January 9, 2018

RE: Waterview Sketch Plan
Updated Master Traffic Impact Study
Springs at Waterview East Preliminary Plan
PCD Project No. SKP 16-002
El Paso County, Colorado
LSC #164691

Figure 3

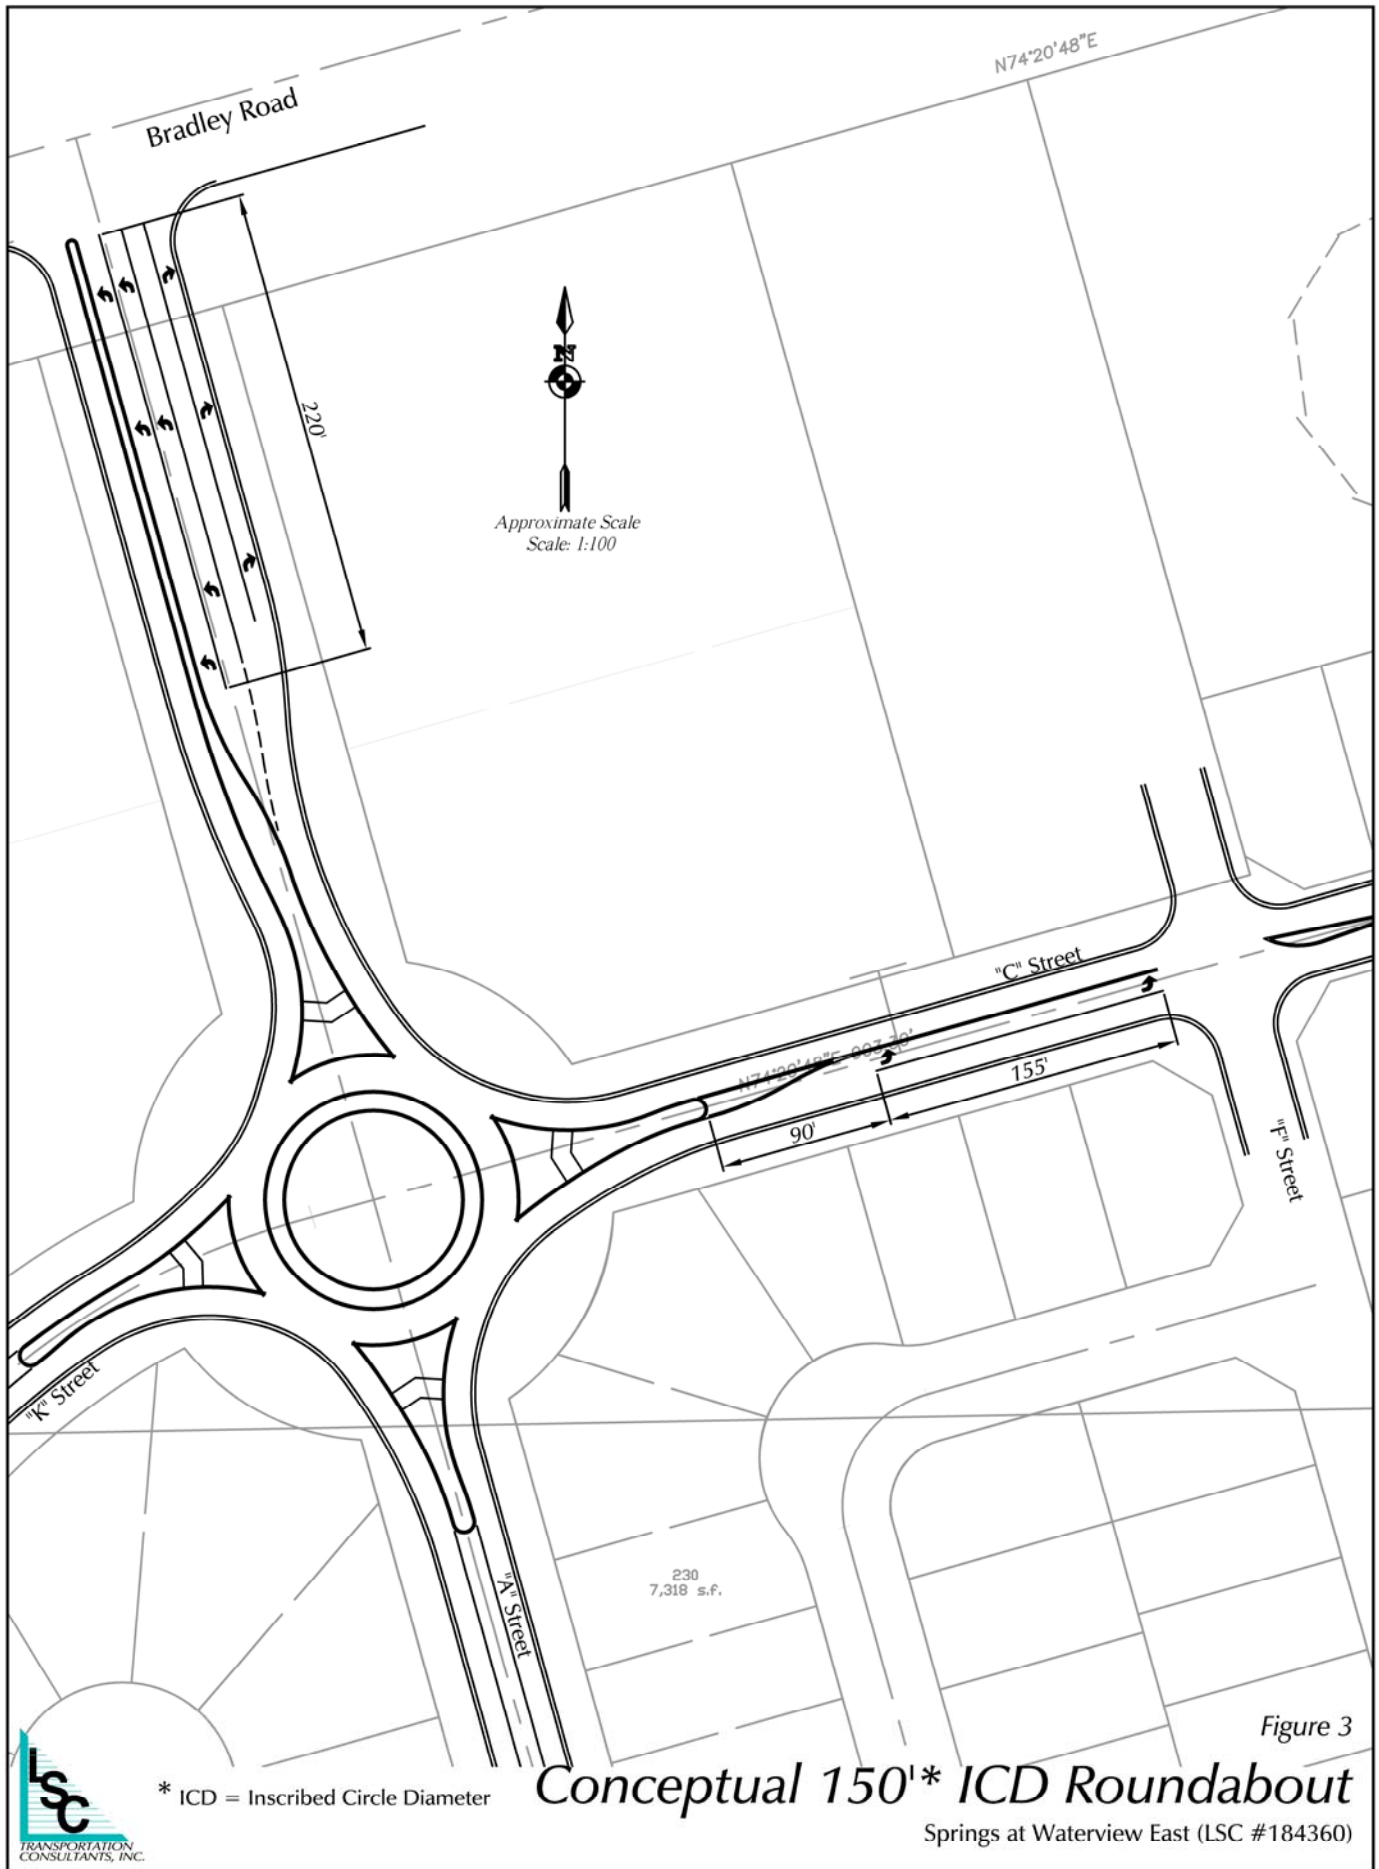
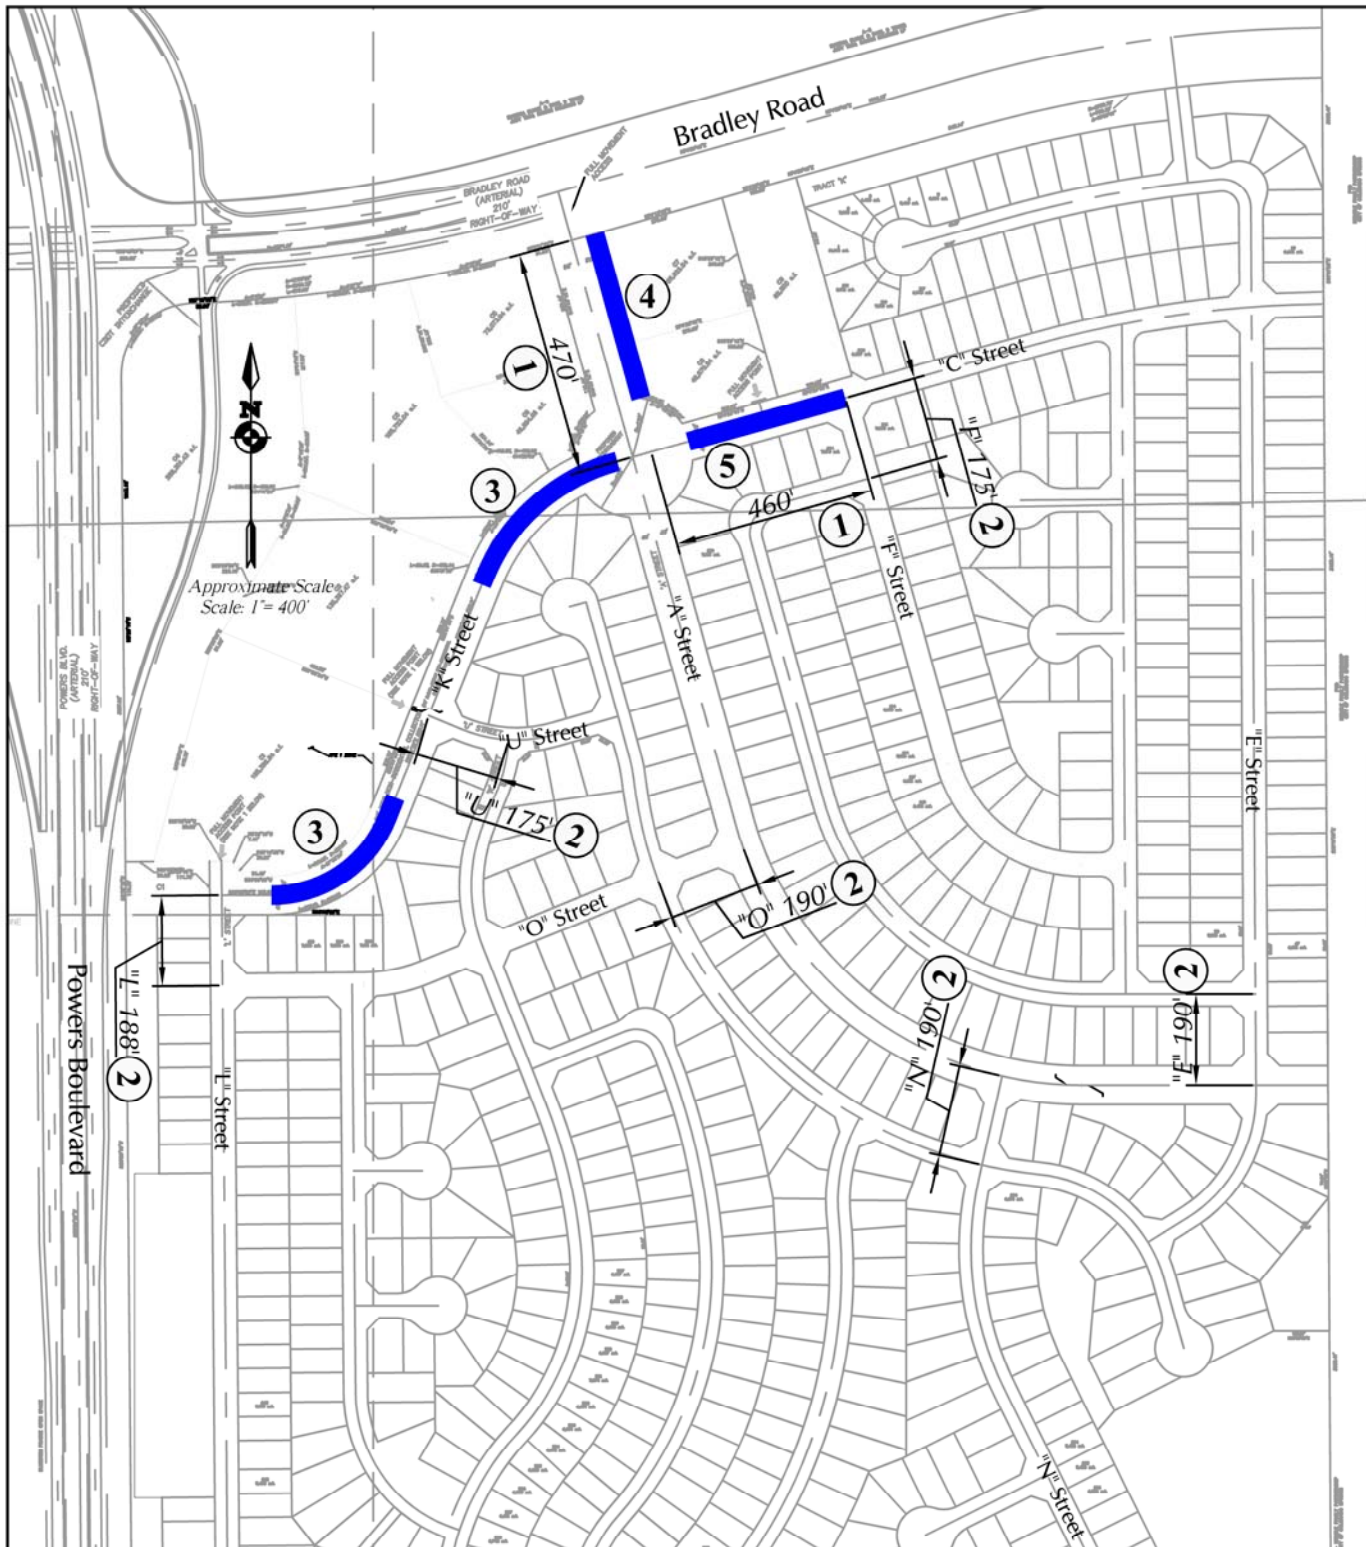
- Provide recommendations for the proposed roundabout geometry. (What is the minimum size for the Roundabout center island?) **Review 2 clarification. Include analysis/recommendations in the report.**
